SUBJECT: WDFW COMMENTS SE-25-00014 Shamkhi

Thank you for the opportunity to comment on SE-25-00014 Shamkhi, a SEPA checklist for proposed improvements to Jay Way, a private road that provides access to the lots located along Jay Way. The Washington Department of Fish and Wildlife (WDFW) is familiar with the area and has been on site for a prior land use application for a Jay Way parcel. We have reviewed the application materials on file and our comments are regarding the project's impact on Fish and Wildlife Habitat Conservation Areas, such as priority habitats and species (PHS), particularly stream and wetland habitats.

## Critical Areas

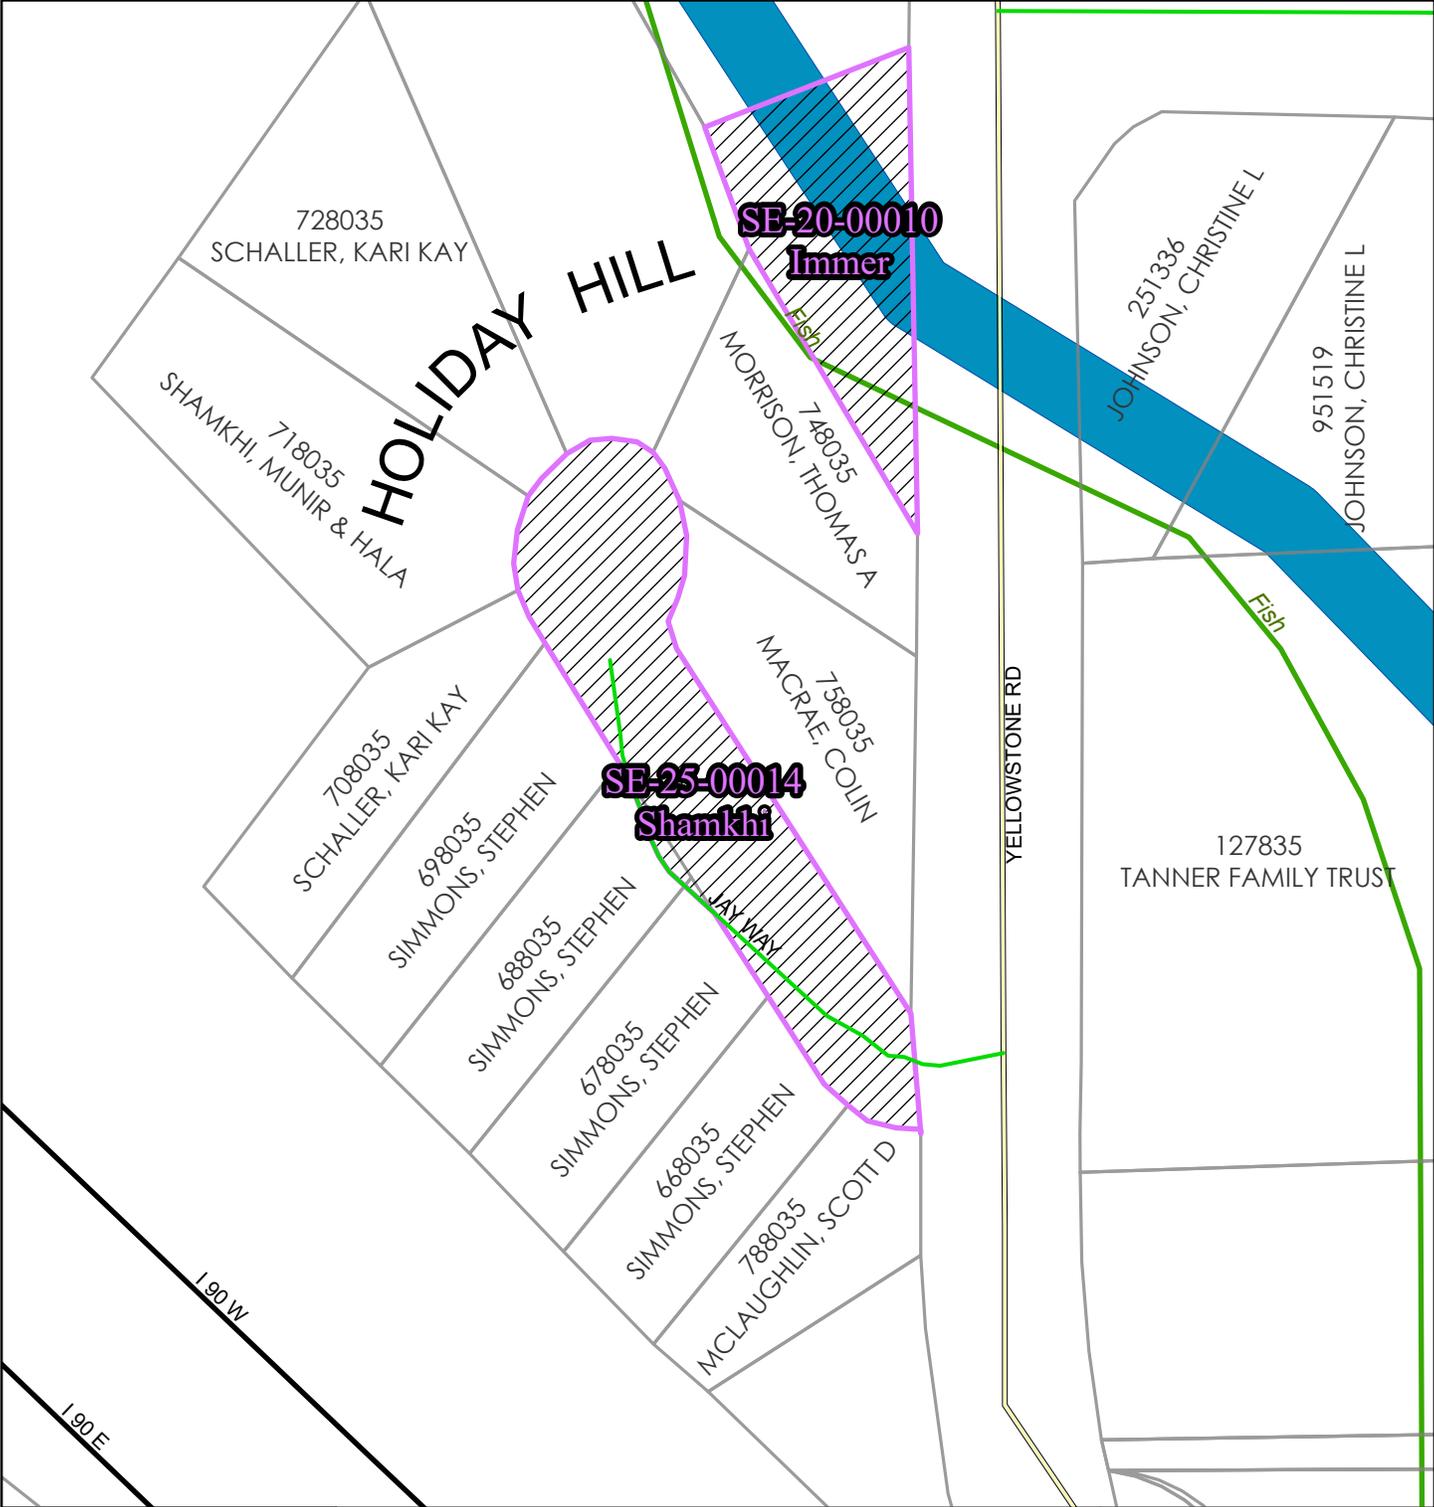
Coal Creek, a perennial fish-bearing tributary to Lake Keechelus, is within the project vicinity, as reflected in the Critical Areas Report. Coal Creek is an important tributary that provides habitat for native salmonids, such as Endangered Species Act (ESA) listed bull trout, and westslope cutthroat trout.

The project area is also located within a large wetland complex. Wetlands are crucial ecosystems that provide habitat for a wide variety of fish, amphibians, reptiles, birds, mammals and beyond. Wetlands also have human-related benefits, such as flood control and water quality improvement. Any infrastructure-related impacts to Coal Creek and the wetlands are likely to degrade the habitat quality and quantity and must be adequately mitigated.

Coal Creek, the Riparian Management Zone (RMZ) of Coal Creek and the wetland complex are designated Fish and Wildlife Habitat Conservation Areas (FWHCAs) under Kittitas County's Critical Areas Ordinance (CAO; Chapter 17A.04) and mitigation for alteration or impacts to these areas shall achieve equivalent or greater biological functions (Chapter 17A.04.070).

The proposed mitigation ratio of 1:1 as suggested in the Critical Areas Report is inadequate to achieve equivalent or greater biological function and needs to be increased in order to be consistent with Kittitas County's CAO. Jay Way is located within wetland buffers and the Coal Creek RMZ. Kittitas County's CAO lists mitigation ratios for Category II forested wetlands from 4:1 (Restoration) up to 16:1 (Enhancement) and Category III wetlands from 2:1 (Restoration) up to 8:1 (Enhancement). While no mitigation ratios are listed for disturbance to riparian areas, the standard is that the mitigation must achieve no net loss, including loss of shade and any impervious surfaces being placed within the RMZ that would preclude ecosystem function.

WDFW requests that Kittitas County include development of a comprehensive Habitat Management Plan (HMP) to be reviewed and approved by WDFW prior to the SEPA determination. A completed HMP is necessary to evaluate if the proposal meets the no net loss standard of critical areas function required for approval of the application. The plan should quantify the proposed development impacts and identify sufficient mitigation for all RMZ and wetland impacts, consistent with the Best Available Science and associated recommendations.
